Your Ref: OWPC25381
Our Ref: R/270/19/HH 20-11-2019
Please ask for:
Zac Denton

Ground and first floor rear extensions - resubmission of R/197/18/HH
1 Pigeonhouse Lane Rustington

Thank you for your internet representation made on 3rd January 2020 which has been recorded as **'an objection'** with the comments as follows:

Drawing Title: PROPOSED ELEVATIONS

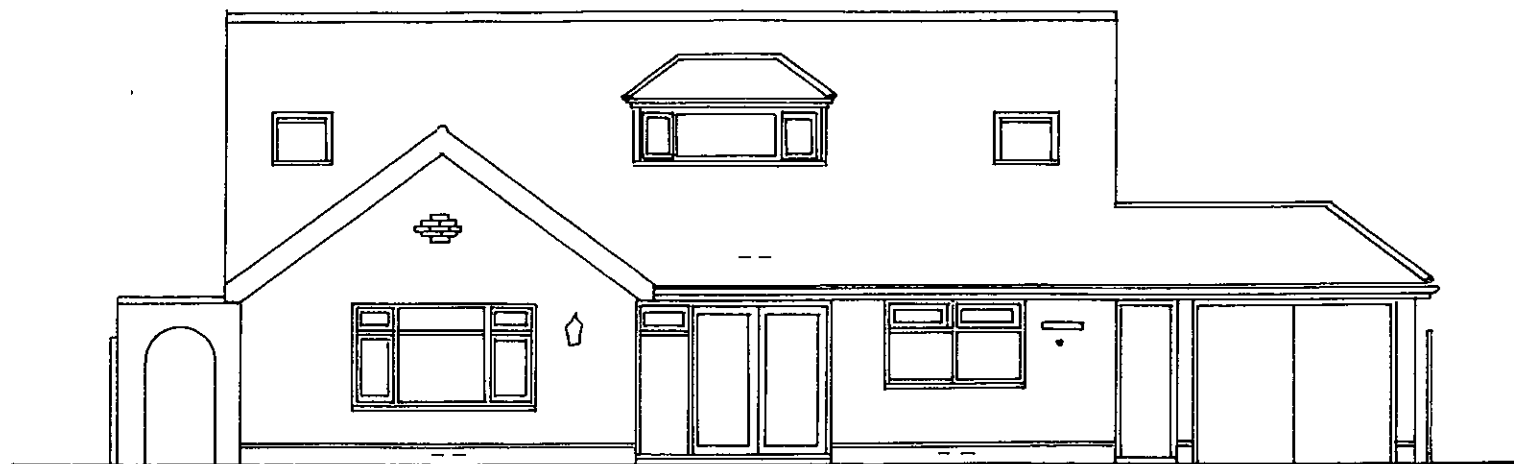
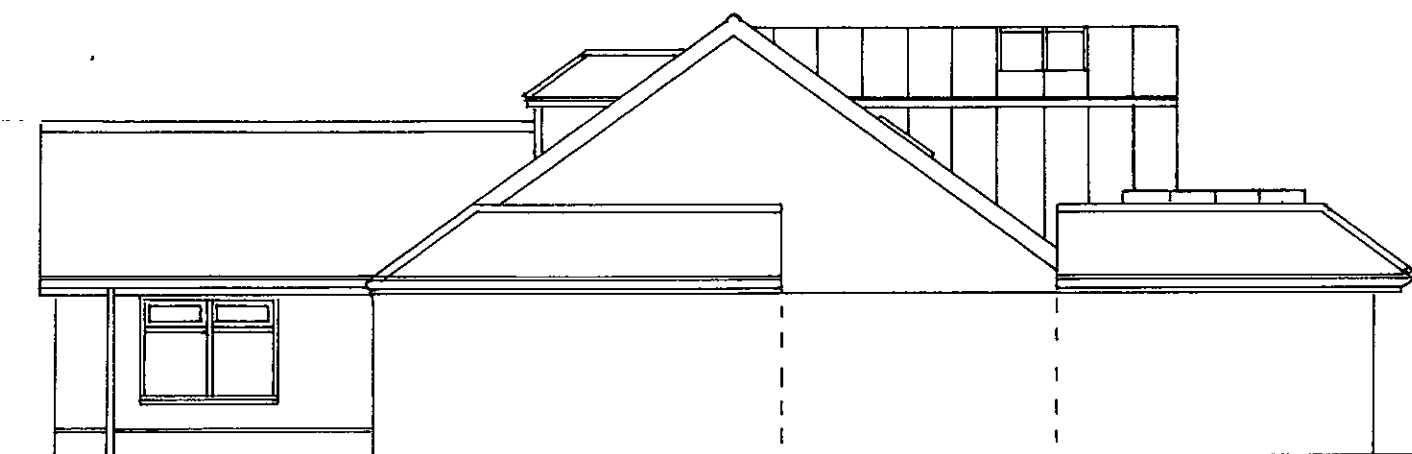
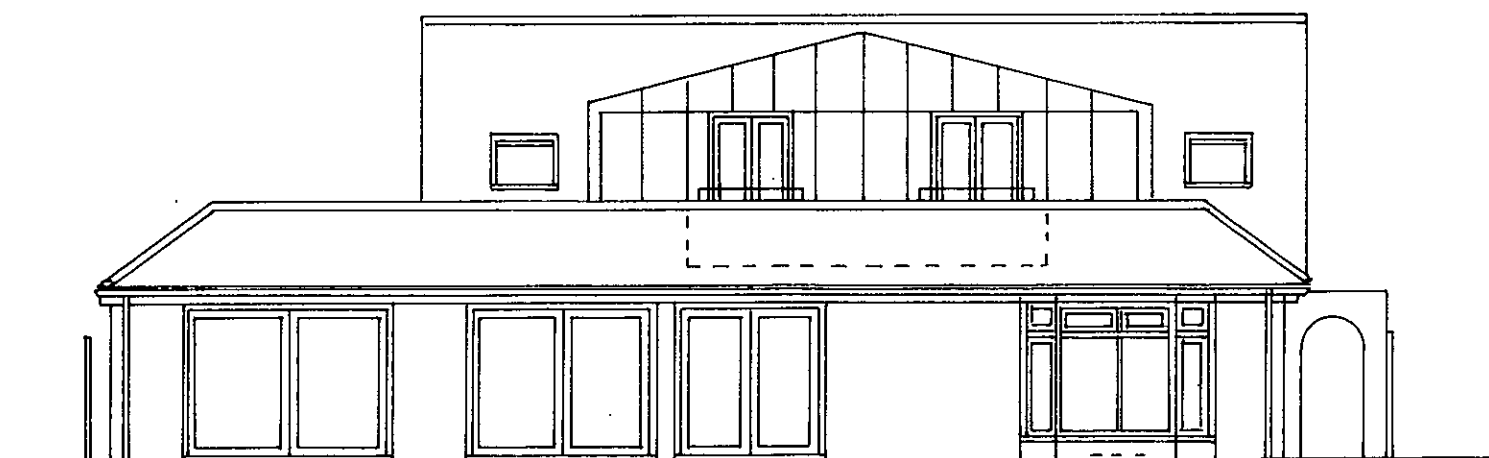
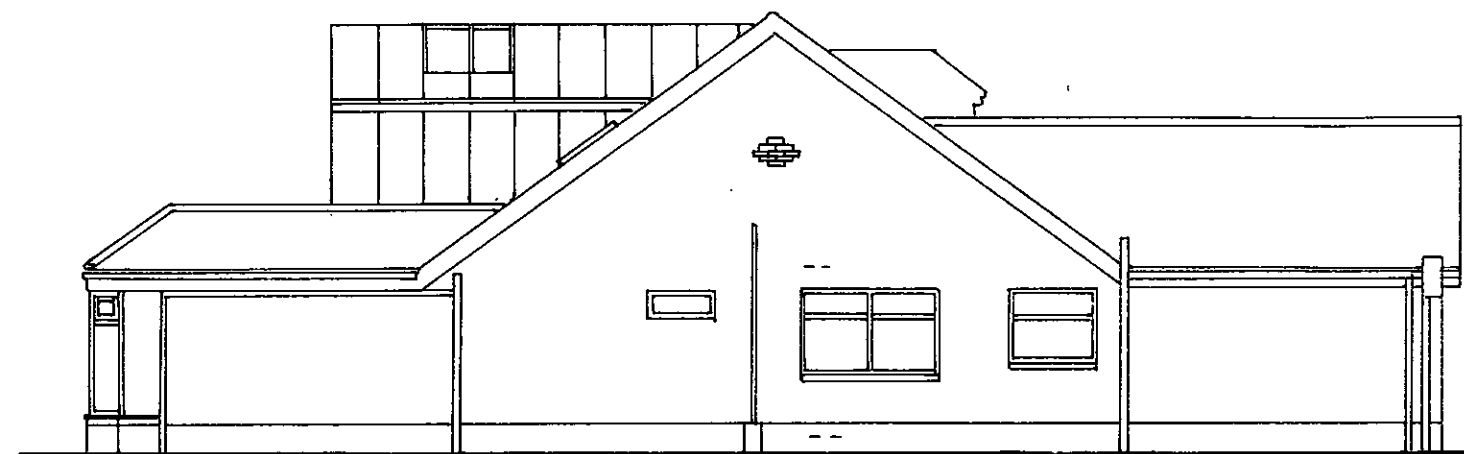
TWO NEW JULIET BALCONIES AND WINDOWS AT EAST 1st FLOOR LEVEL.

Creates overlooking directly into my house. Patio and garden area.

Loss of Privacy.

Loss of Amenity.

Plans as submitted provide inadequate detail re GREY ZINC ROOF and overall visual impact.
